Rezoning Transportation Analysis
Petition Number: Insert Zoning Petition #2021-018
General Location Identifier: Tax ID 07908301

Reviewer: Eric Lemieux, PE
 Eric.Lemieux@charlottenc.gov
 704-336-2683

Revision Log:	Date	Description
	02-25-21	First Review (EL)

RZ-1

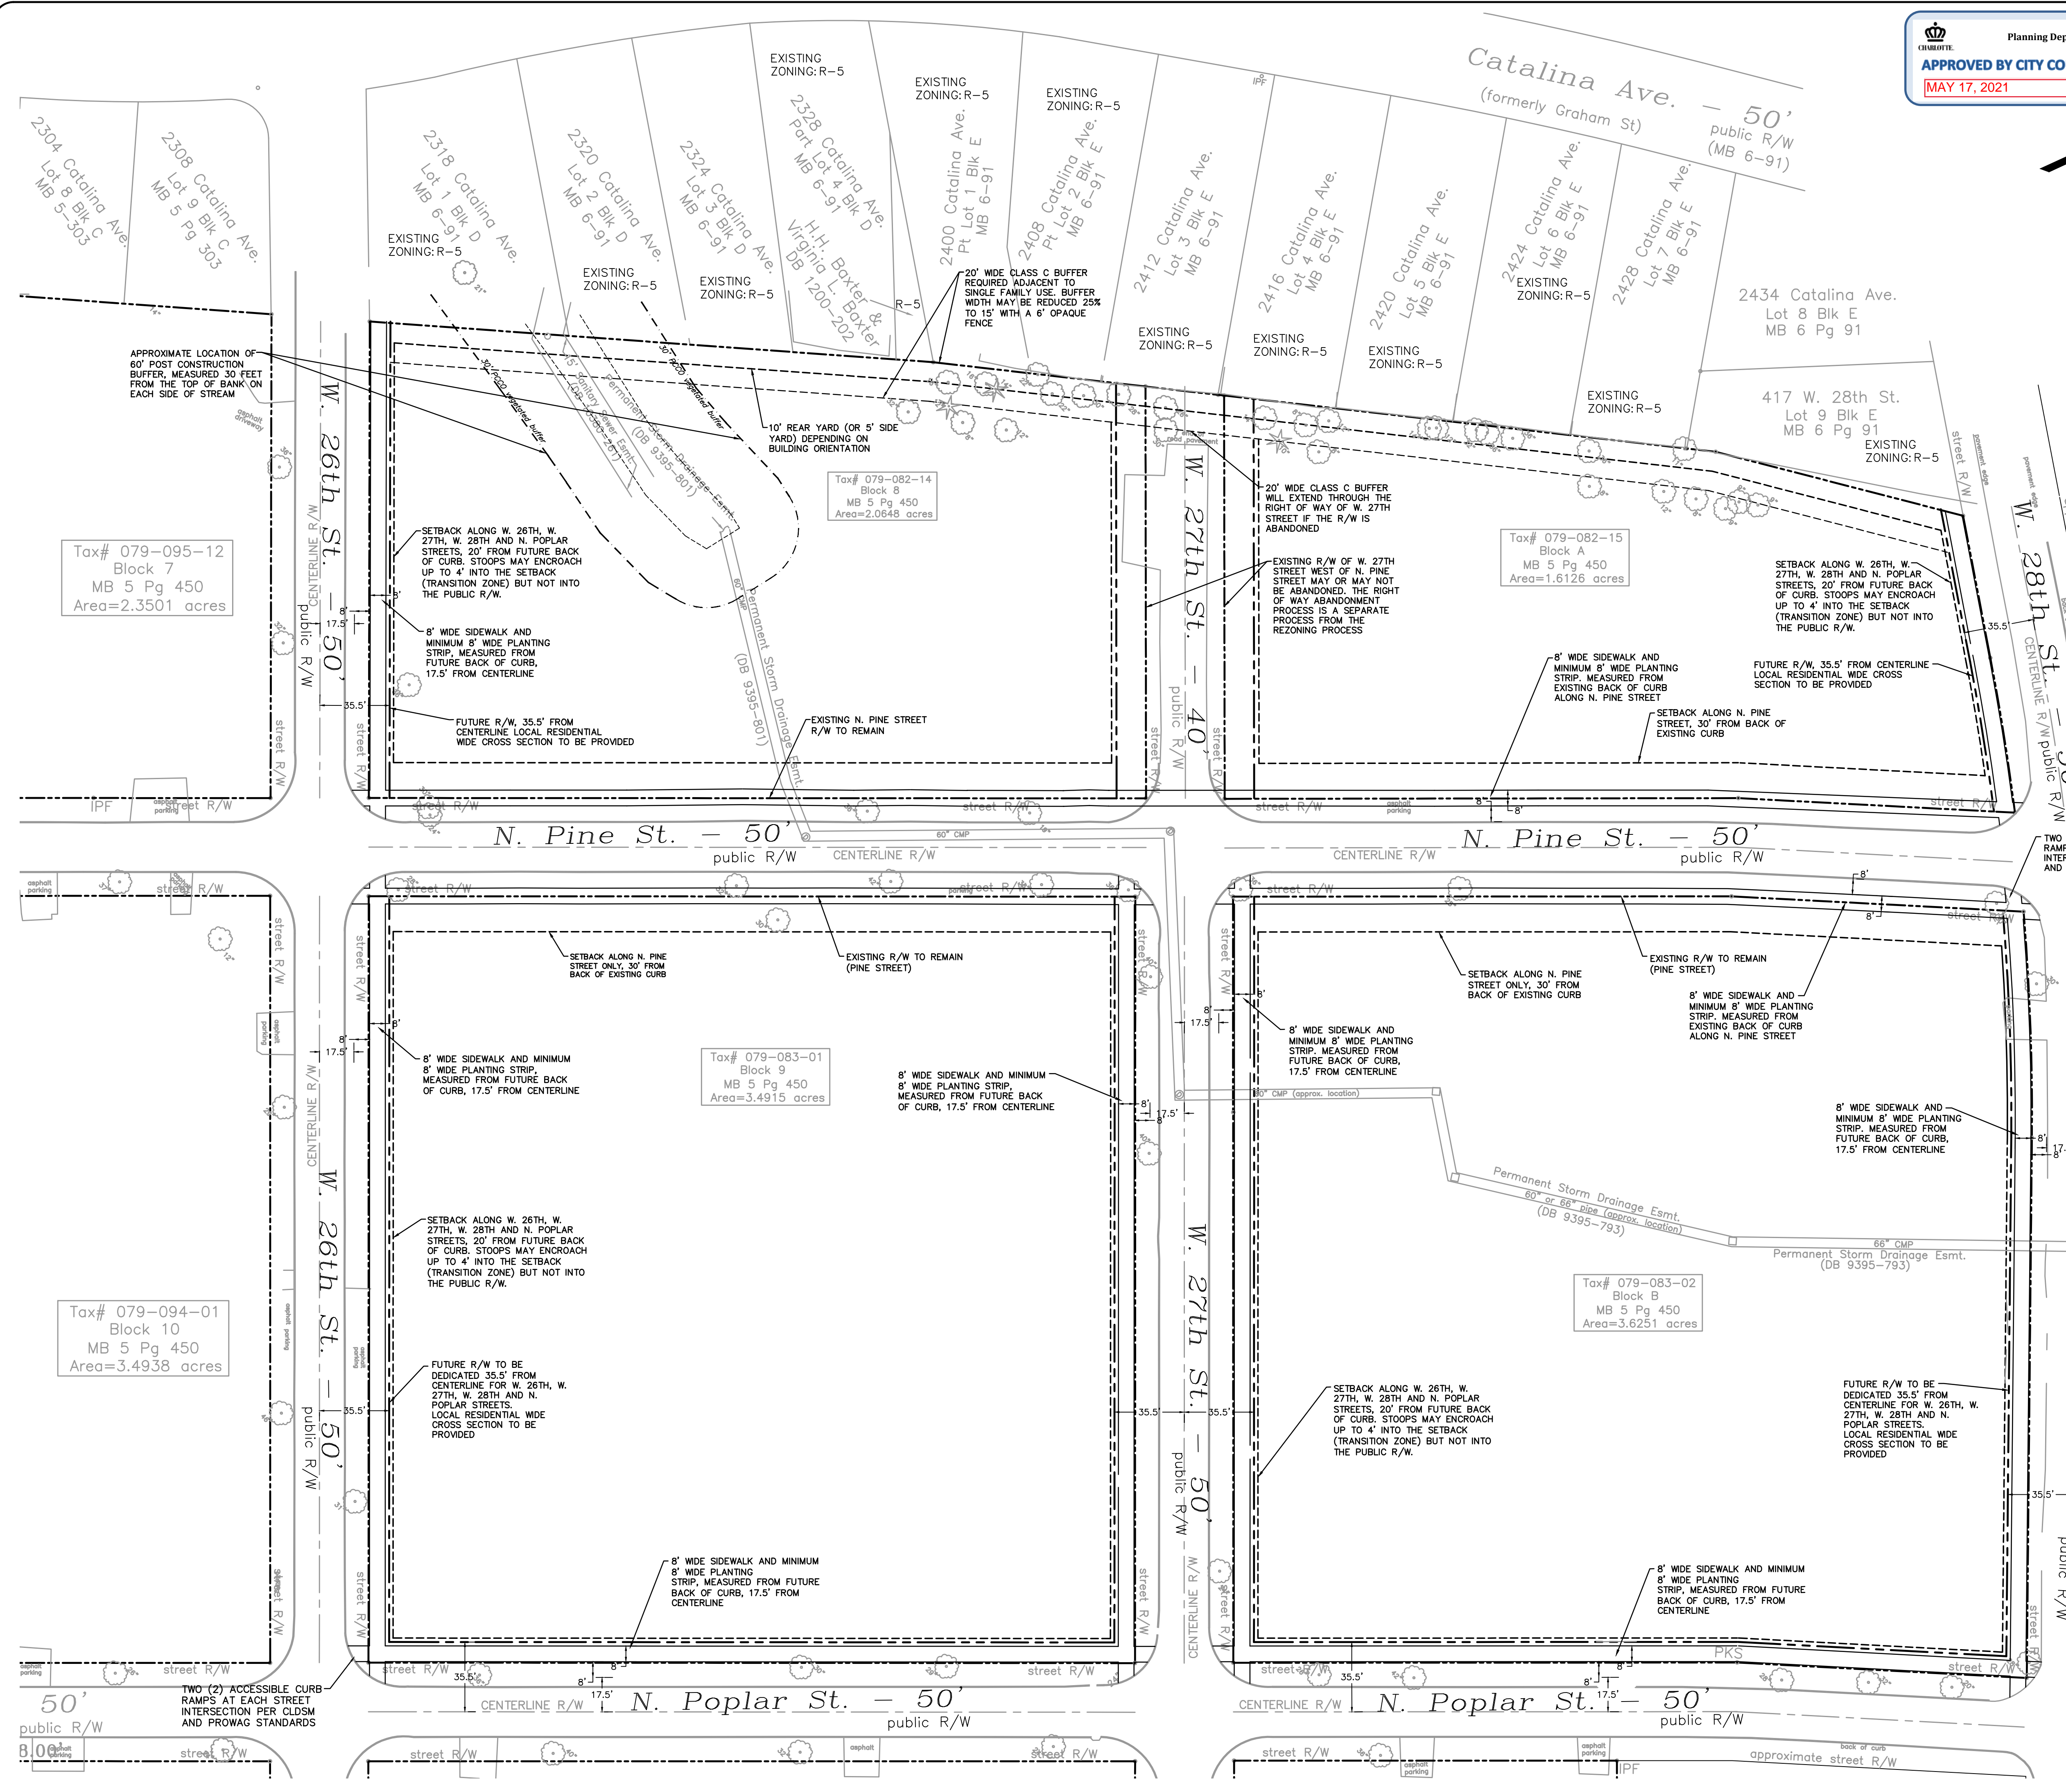
5. A site plan notespecifying dedication and fee simple conveyance of all rights-of-way to the City before the site's first building certificate of occupancy is issued is needed. CDOT requests rights-of-way set at 2' behind back of sidewalk where feasible.
6. A site plan note specifying that all transportation improvements will be approved and constructed before the site's first building certificate of occupancy is issued is needed. The petitioner may phase transportation improvements if said improvements and phasing are explicitly described in site plan notes.
7. On sheets RZ-1 and RZ-2, remove call-out to abandon and remove W. 27th Street. Also, remove the site conditional note 3. Access, Buffers, Screening, Open Space and Pedestrian Circulation, Note I. The abandonment of W. 27th Street is not consistent with the USDG Standards (see image below).

RZ-2

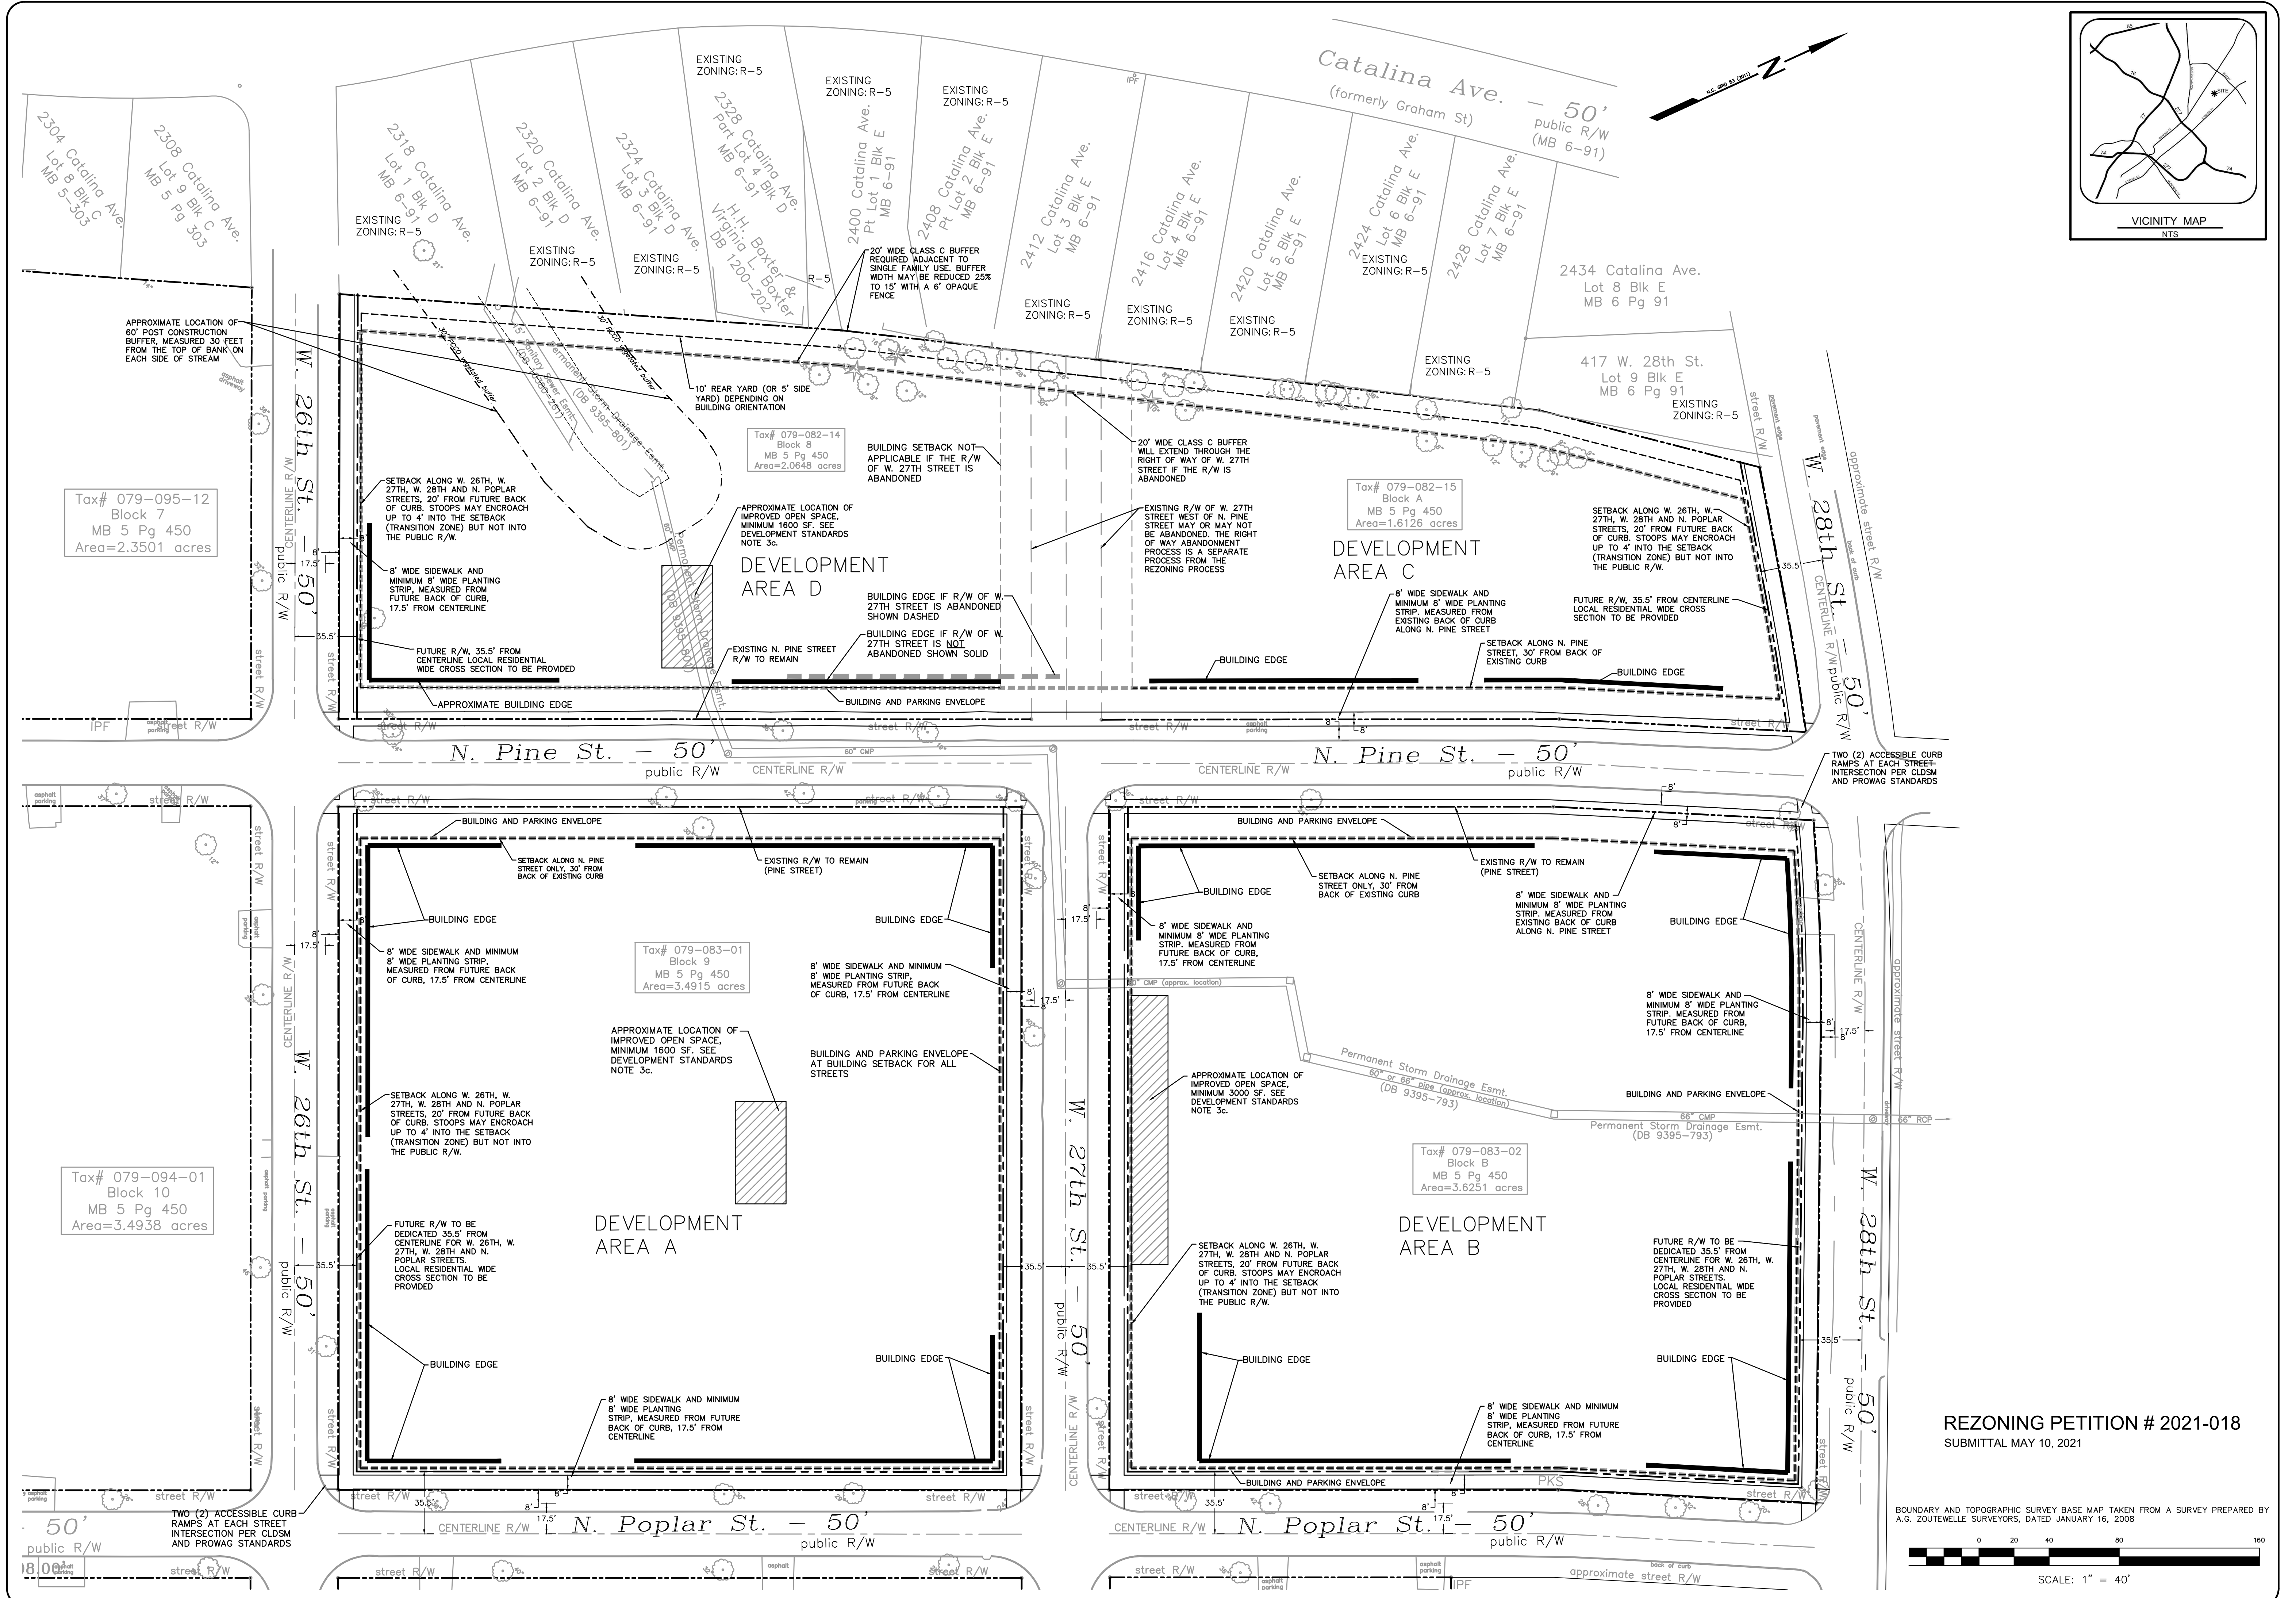
Label and dimension the curb and gutter from the centerline for each road on the site plan.

3. Revise site plan and conditional note(s) to commit to dedicate the future right-of-way from all road centerlines. The site plan shall label and dimension the right-of-way from the road centerline.
4. Revise the site plan to reflect the commitment within conditional note (Section 3.d.) to include an 8-foot planting strip and 8-foot sidewalk along all road frontages. Two accessible ramps will be required to provide accessible street crossings across each road per CLDSM standards and Public Right-of-Way Accessibility Guidelines (PROWAG).
